**Re: SSD-49472213, Pathways Cremorne Seniors Housing, 50-88
Parraween Street, 59-67 Gerard Street, Cremorne, North Sydney LGA**

I do not support this proposed development for the reasons outlined in this submission.

DEMOLITION SITE PLAN

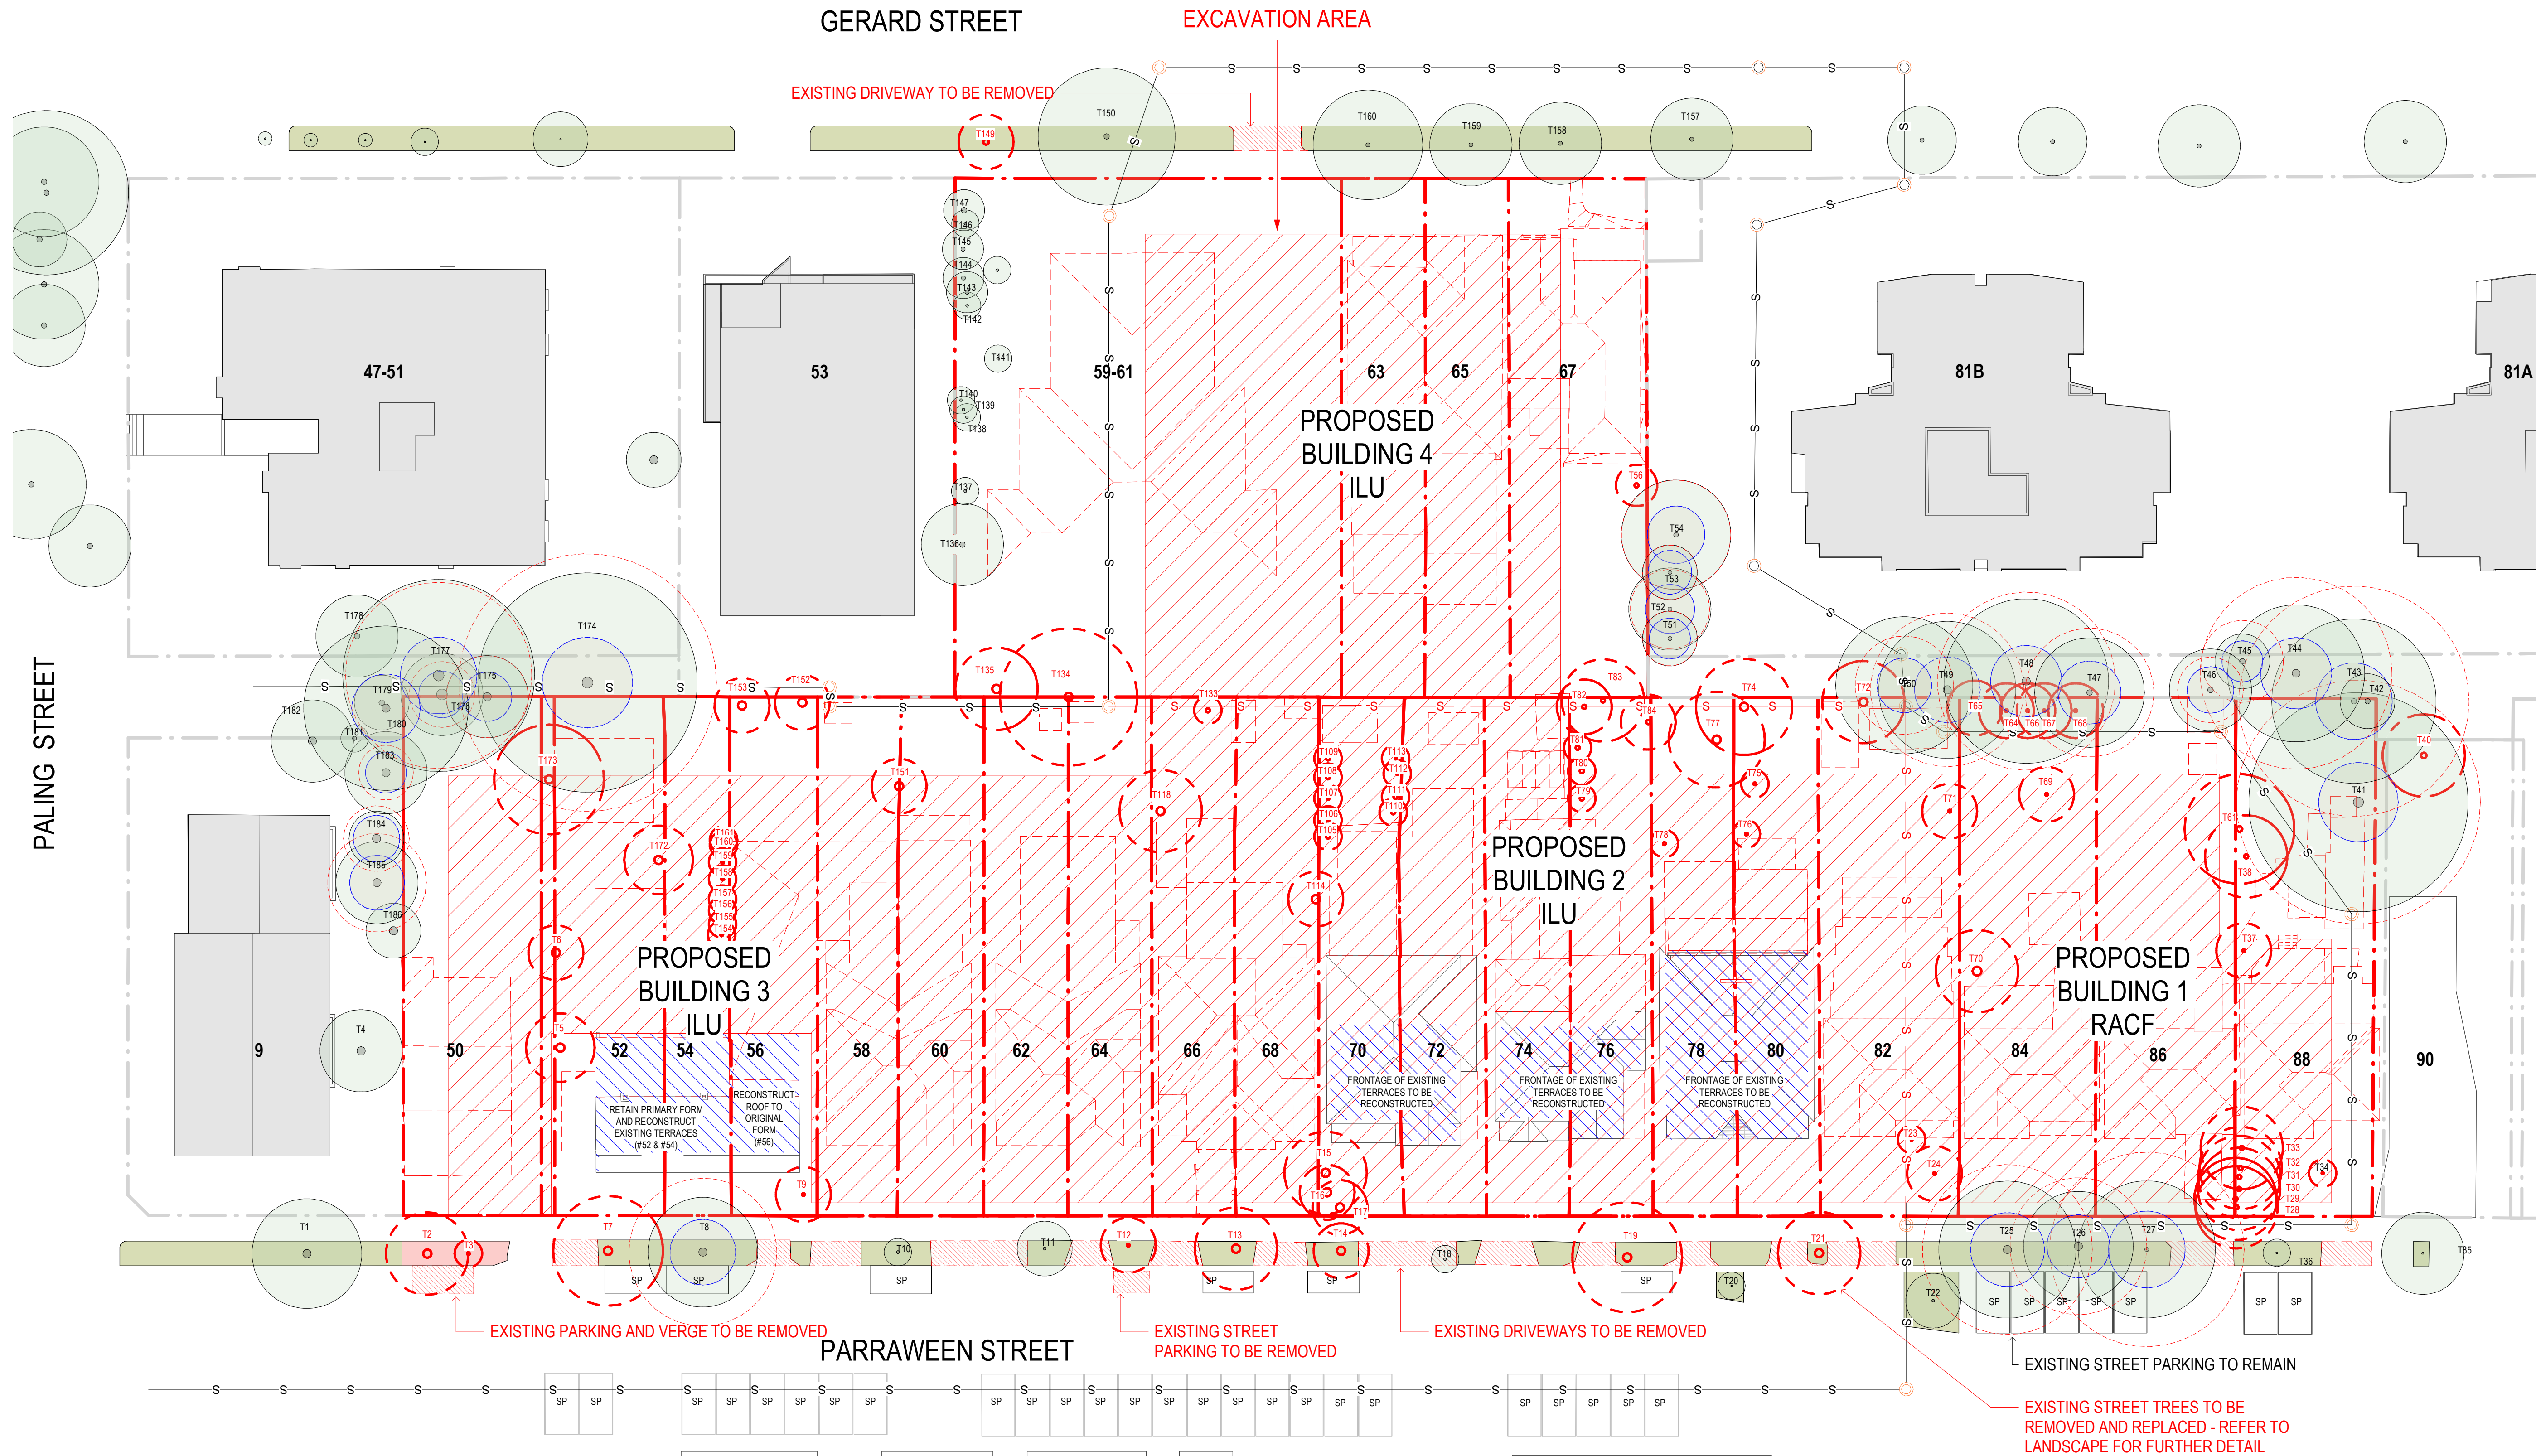
- The proposed development results in the loss of these items of heritage significance to Cremorne. While the developer proposes to reconstruct 3 of the cottages, such reconstruction involves loss of the original items and materially reduces their heritage significance.
- The heritage significance of the Parraween Street cottages has been confirmed by an expert study undertaken by independent heritage experts, Lucas Stapleton Johnson & Partners, and supported by the Land and Environment Court, when on 26 July 2023, the Court dismissed the developer's appeal against the Interim Heritage Order that had been issued to protect these dwellings while assessment and inquiry on their heritage significance were carried out.

BASEMENT PLAN

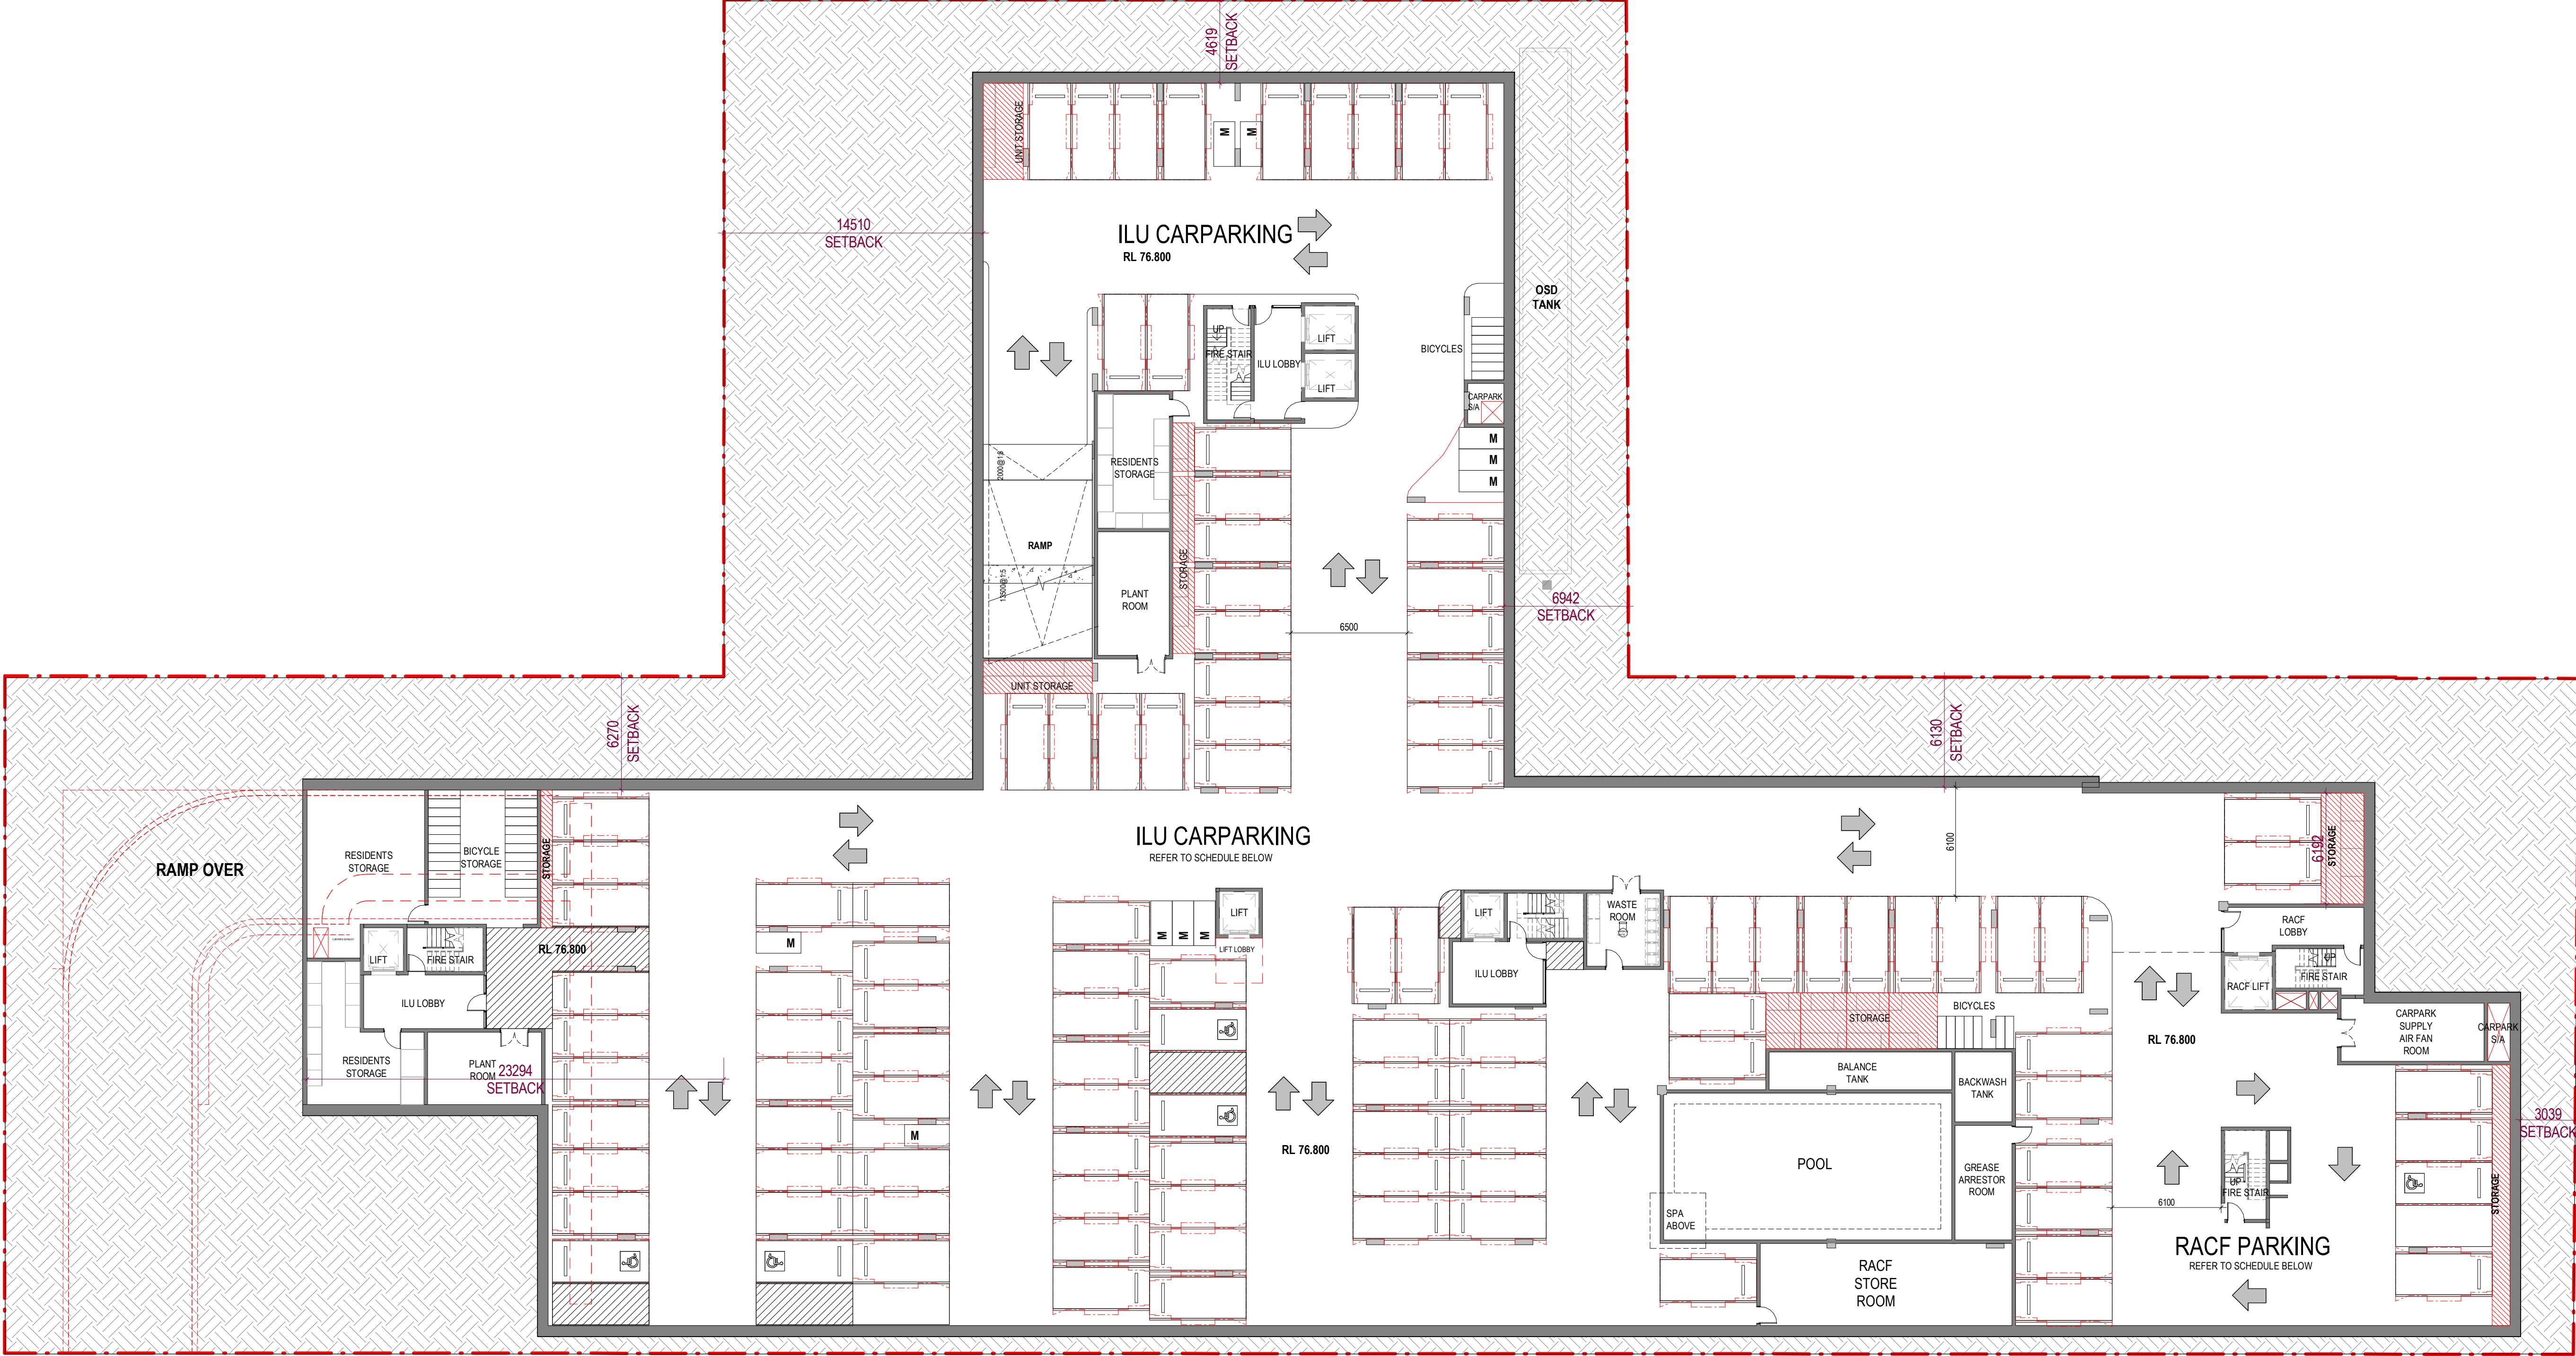
- The proposal to have only one driveway to enter and exit the site for 134 cars plus delivery trucks and service vehicles will create a bottleneck.
- The impact on the existing residents on Parraween Street need to be considered, because it is a residential street where people live.

- The traffic issues identified will adversely impact the amenity of Parraween Street. The single driveway for 134 cars plus delivery trucks and service vehicles will result in a major bottleneck resulting in traffic, noise and safety issues for residents and pedestrians, and reduce the attractiveness of Parraween St as a destination for social gathering.
